AND IN THE MATTER OF THE NORFOLK VANGUARD OFFSHORE
WIND FARM PROJECT

AND IN THE MATTER OF THE NATIONAL FARMERS UNION AND
THE VATTENFALL AGENTS KNOWN AS THE LAND INTEREST
GROUP

OUTLINE REPRESENTATIONS

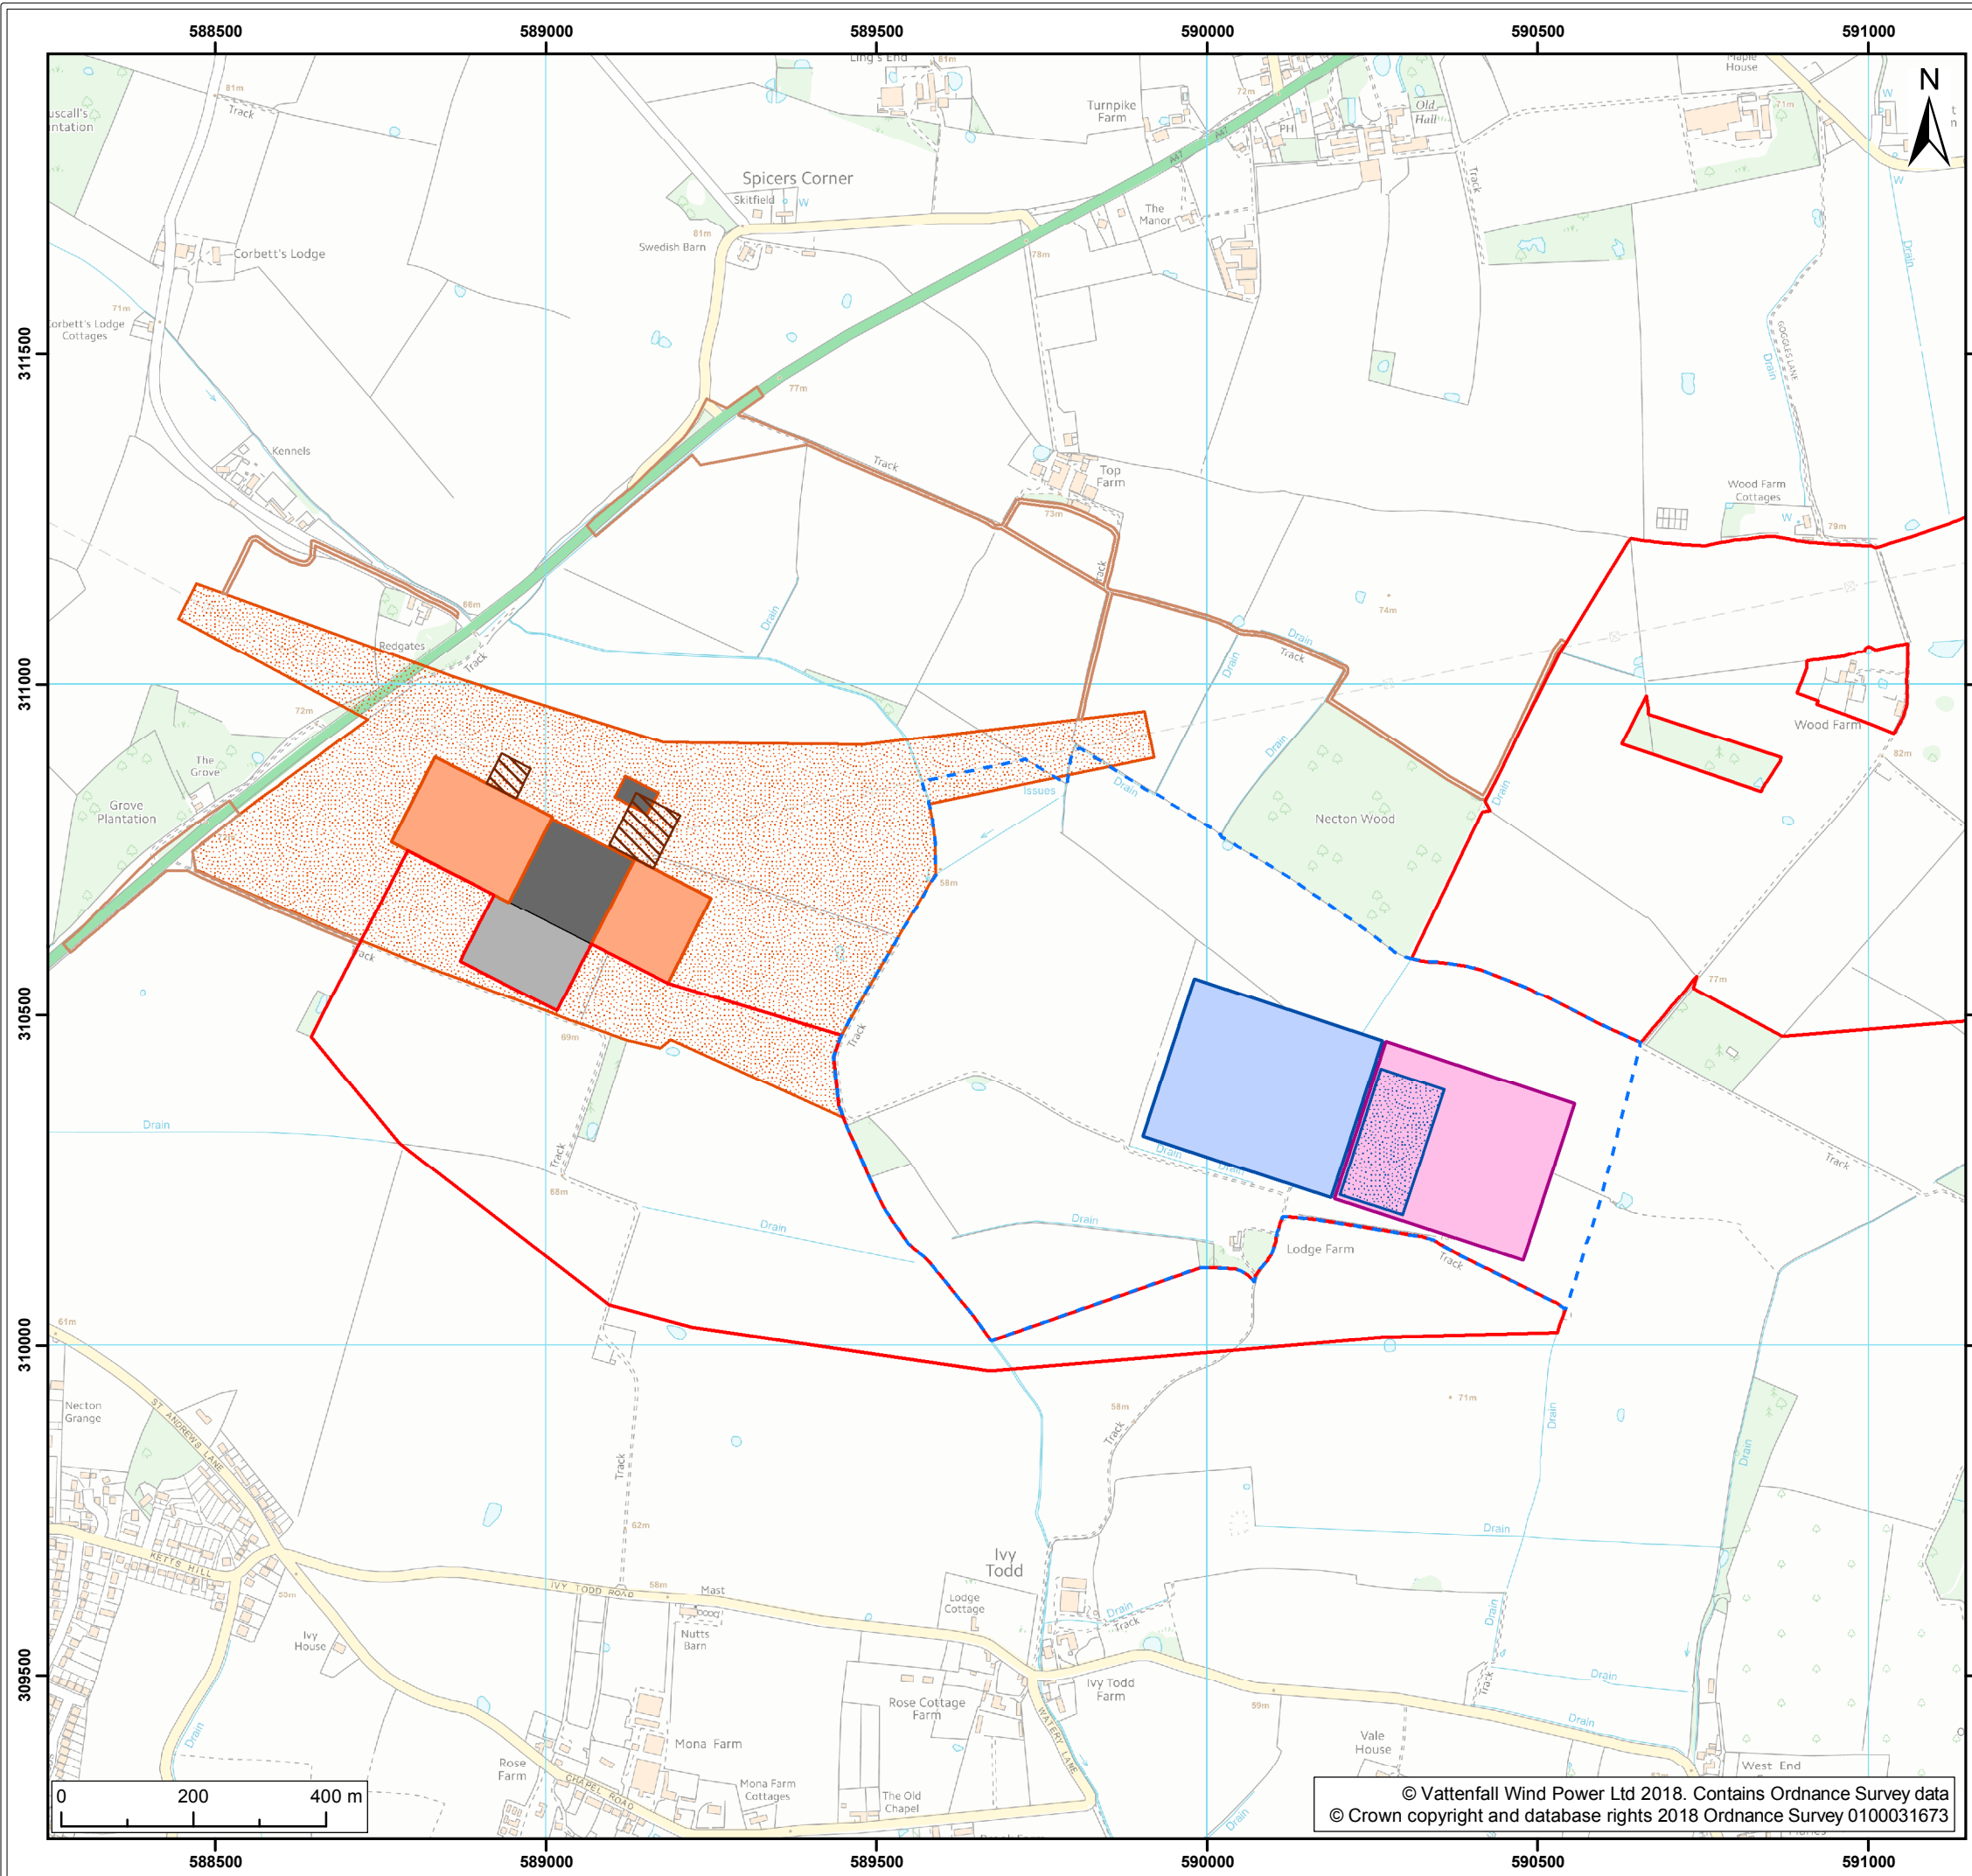
4.3. At the present time the plans are showing for the new converter substation to be located at the top of a hill on a very prominent site near to Necton Wood. Further to a site visit on 10th September 2018 to look at the proposed elevated site, information has been requested on why such a prominent site position has been chosen as it will be visible particularly from the south and west.

4.4 Questions have been raised as to why the substation is not being sited nearer to the National Grid substation on land lying to the north of the existing substation. This land lies lower down and is not as visible as the proposed location.

4.5 Vattenfall has stated that they have followed the Horlock Rules when considering site selection. Screening provided by land form and existing features should be taken advantage of and this is not the case with the proposed site.
